COLORADO
Department of Transportation
Region 2
Traffic & Safety - Access Permits

025/El Paso County

RE: Urban Landing PUDSP Combined PUD/Preliminary Plan

URBAN LANDING PUD DEV. PLAN & PRELIMINARY PLAN		
	PRELIMINARY GRADING AND UTILITY PLAN		
DESIGNED BY	MAW	SCALE	DATE 4/01/2024
DRAWN BY	MAW	(H) 1" = 40'	SHEET 6 OF 9
CHECKED BY	(V) 1" = N/A	JOB NO.	1308.01

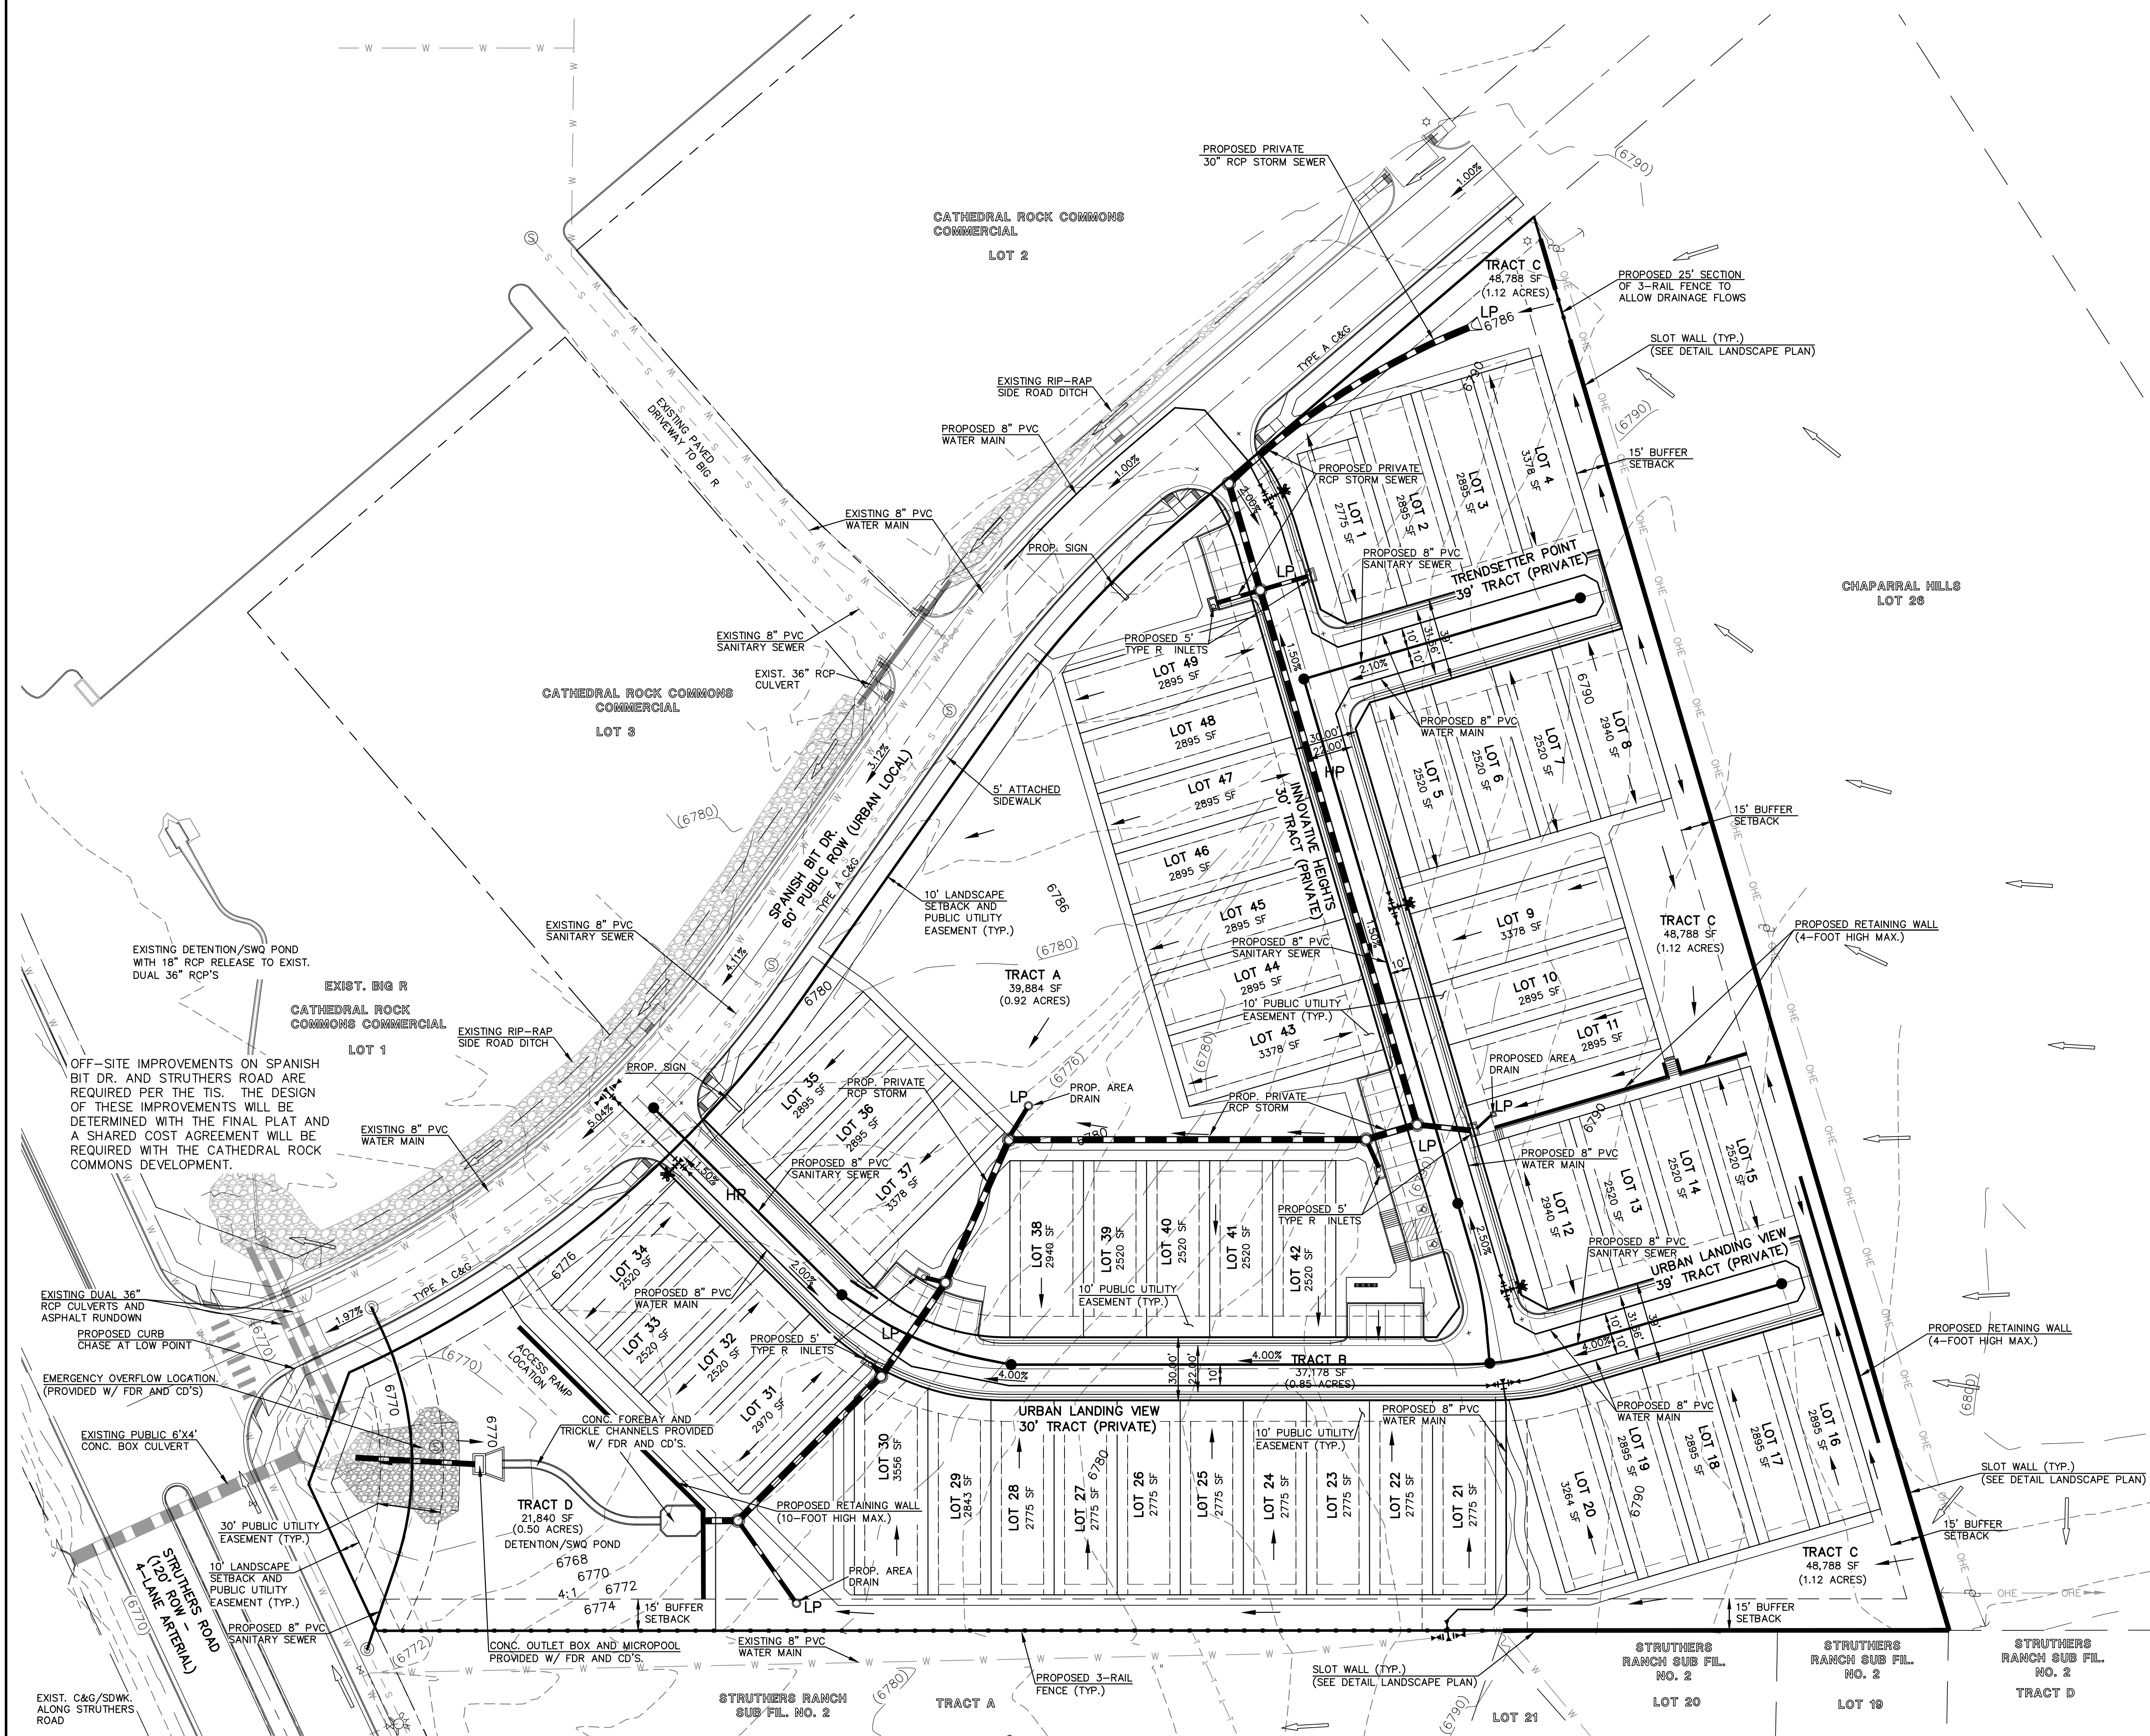
- Plan Comment:
 - As the design progresses, include detailed design plans of the pond.
- Report Comments:
 - For the next submittal, include design point comparison for the flow into the existing culvert beneath Struthers.
 - For the next submittal, include analyses of the Struthers culvert for existing/proposed/pond overtopping events. This will help to determine if there are any impacts to CDOT ROW from either outfall velocity or Struthers road overtopping.
- This is the Preliminary Report, these comments can be addressed with the Final Design as compared to a revised Preliminary report.
